Suffolk County Council (20041323)

Comments on any other submissions received
at Deadline 8

Bramford to Twinstead (EN020002)

8.9.5 (B) Temporary and Permanent Access Technical Note – Suffolk County Council (Clean) [REP8-030]

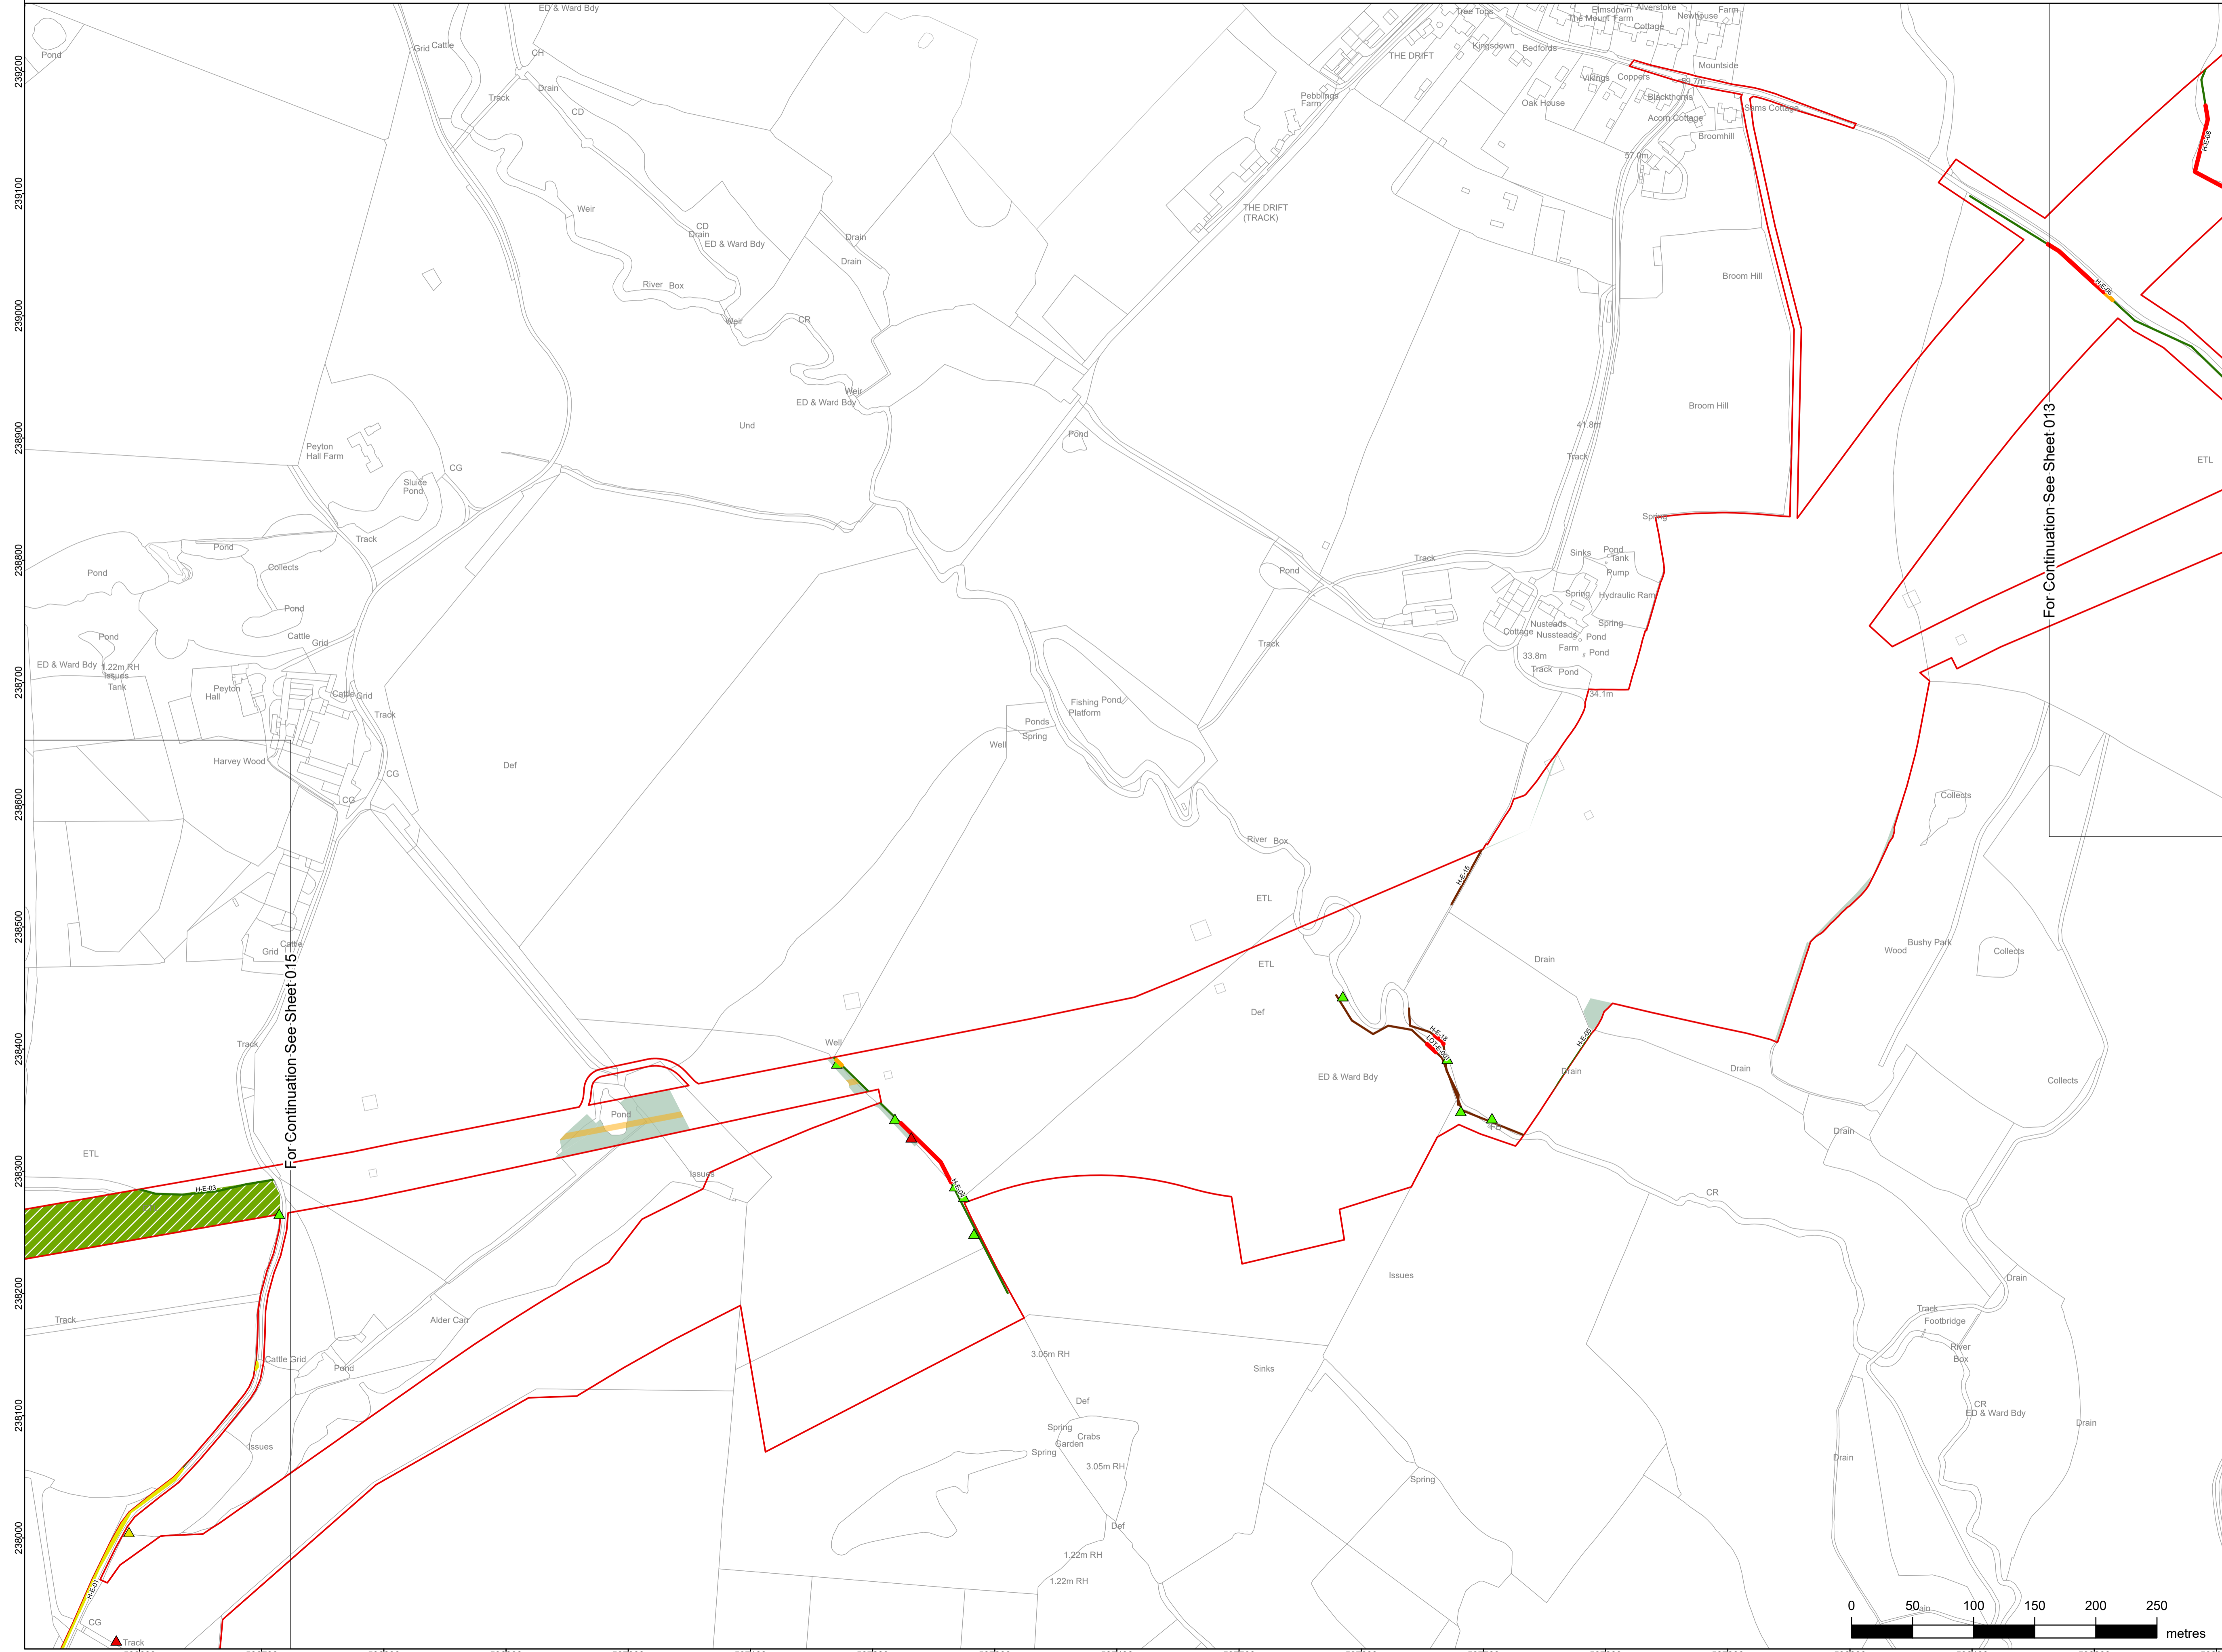
1c	D-DAP2 Millwood Road (Access to		<p>To the north and south of the access, there is some vegetation and dense</p>	<p>It is not clear, whether the hedge (which would likely not just need to be pruned, but at least in parts removed to enable the visibility splays), and which is referred to as ‘<i>some vegetation and dense foliage</i>’, is H-D-07, as</p>

Dedham Vale East CSE compound)		foliage which has grown to the edge of the carriageway, which would require pruning to achieve the required sightlines.	the label on sheet 12 of the Vegetation Retention and Removal Plan [REP7-008] does not connect to the hedge shown. However, where it is not covered up by orange lines, which indicate coppicing of hedgerows, small sections of dark green lines identify this as an important hedgerow under the 1997 Hedgerow Regulations. SCC (Landscape) considers that the Applicant should be more accurate in its descriptions, especially where survey information is available.
1d	F-AP4 Stoke Road, Leavenheath (Access to Dedham Vale West CSE compound)		To the north of the access, there is some vegetation and hedges which would require pruning to achieve the require sightlines. To the south of the access, there is dense vegetation which would require pruning to achieve the require sightlines. The Applicant does not see this pruningose as an impediment to the safe provision of access at this location.	<p>The current proposals on Sheet 15 of the Vegetation Reinstatement Plan [REP7-009] do not reflect the requirements for visibility splays laid out in the Technical Note. SCC (Landscape) understand that it may not be possible to allow the coppiced hedgerow to the north-east of the access to regenerate naturally. It seems unlikely that a new tree can be planted, where an existing tree would first have been removed [REP7-008]. The proposed hedgerow planting along the access track will need to be amended to allow for the visibility splays.</p> <p>SCC (Landscape) considers that, when the changes in reinstatement and mitigation planting will be made, a placemaking approach will be required and new hedgelines (and trees) should be provided on either side of the access, in such a way that that they will accommodate the required visibility splays, while delivering adequate mitigation.</p>
